Memorandum
Department of Planning and Development
Planning Division

Re: Proposed University Credit Union, 1071 Brighton Avenue

The University Credit Union building is proposed for 1071 Brighton Avenue. This building is in the B2 Zone. Elevations dated 08/30/06 were reviewed for this memo.

1 NORTH ELEVATION - ENTRANCE  
 1/8" = 1'-0"

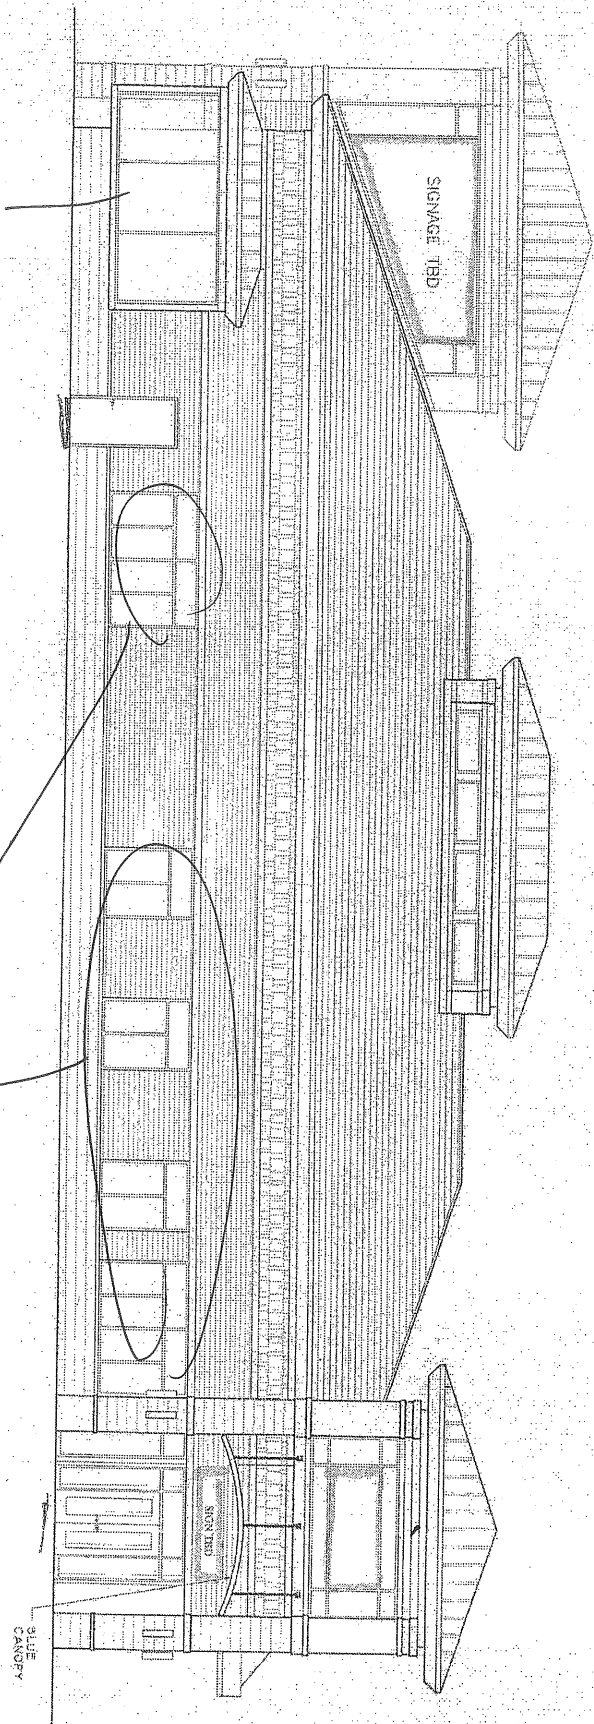
The North Elevation facing the parking lot is indicated as the "Entrance". There is a tower with an entrance door and a curved blue metal canopy. This entrance tower is on the northeast corner with doors on each side of the building. There is signage above the door, and on the upper level of the tower. Fenestration is shown, but it is not clear if this is translucent or spandrel glass.

1 EAST ELEVATION -- ENTRANCE  
A2.5 1/8"=1'-0"

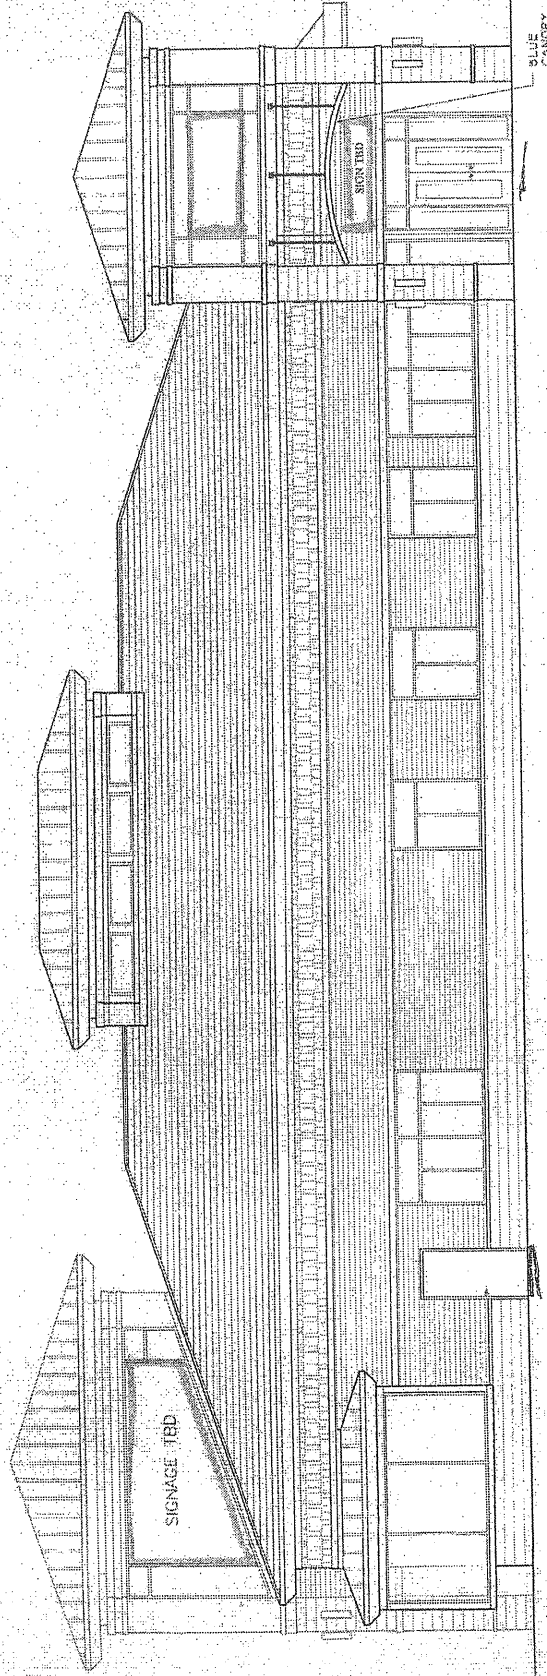
The East Elevation is indicated as the "Entrance" on the elevations. There is a tower with an entrance door and a blue metal canopy. The elevations indicate that the signage on this facade is to be determined. There is a monitor roof with a clerestory windows. It is not clear if these are translucent or spandrel glass. Fenestration is shown, but it is not indicated whether this is translucent or spandrel glass. There is a bay window that wraps the southeast corner – again the glass needs to be specified.

1 SOUTH ELEVATION - BRIGHTON AVE  
 1/8"=1'-0"

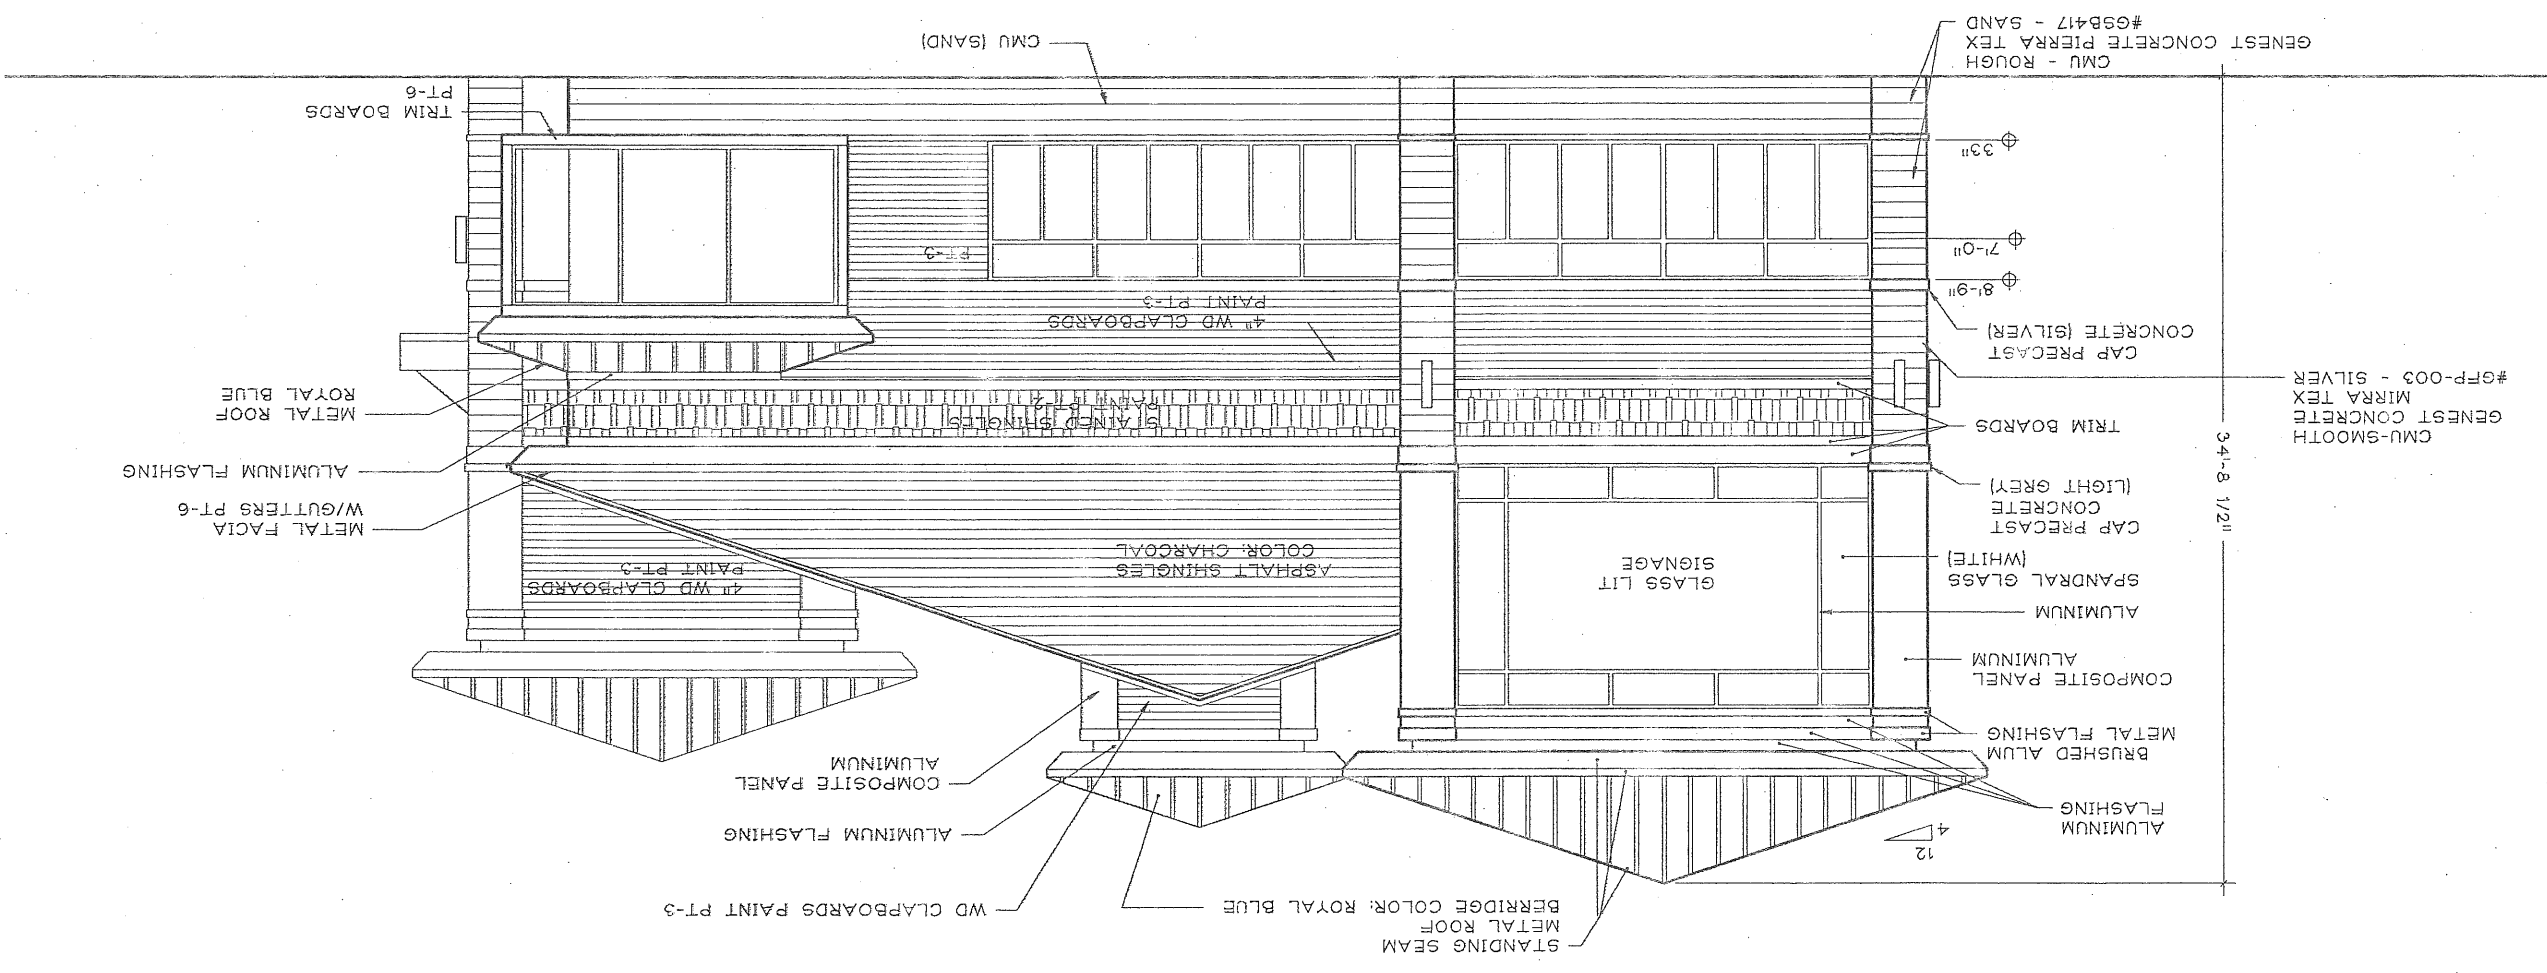
The South Elevation along Brighton Avenue includes a tower element with a large panel of glass. It signage on the upper portion. No building entrance is shown on Brighton Avenue. There is fenestration shown on this elevation at the first floor level which appears to be windows. It is not clear if translucent glass or spandrel glass is proposed. There is a bay window feature on this facade which wraps around to the East Elevation.

It is not clear whether transparent or spandrel glass is proposed for the facade of this building. The West Elevation along Taft Avenue includes a narrow band of windows that appear to be higher than pedestrian level.
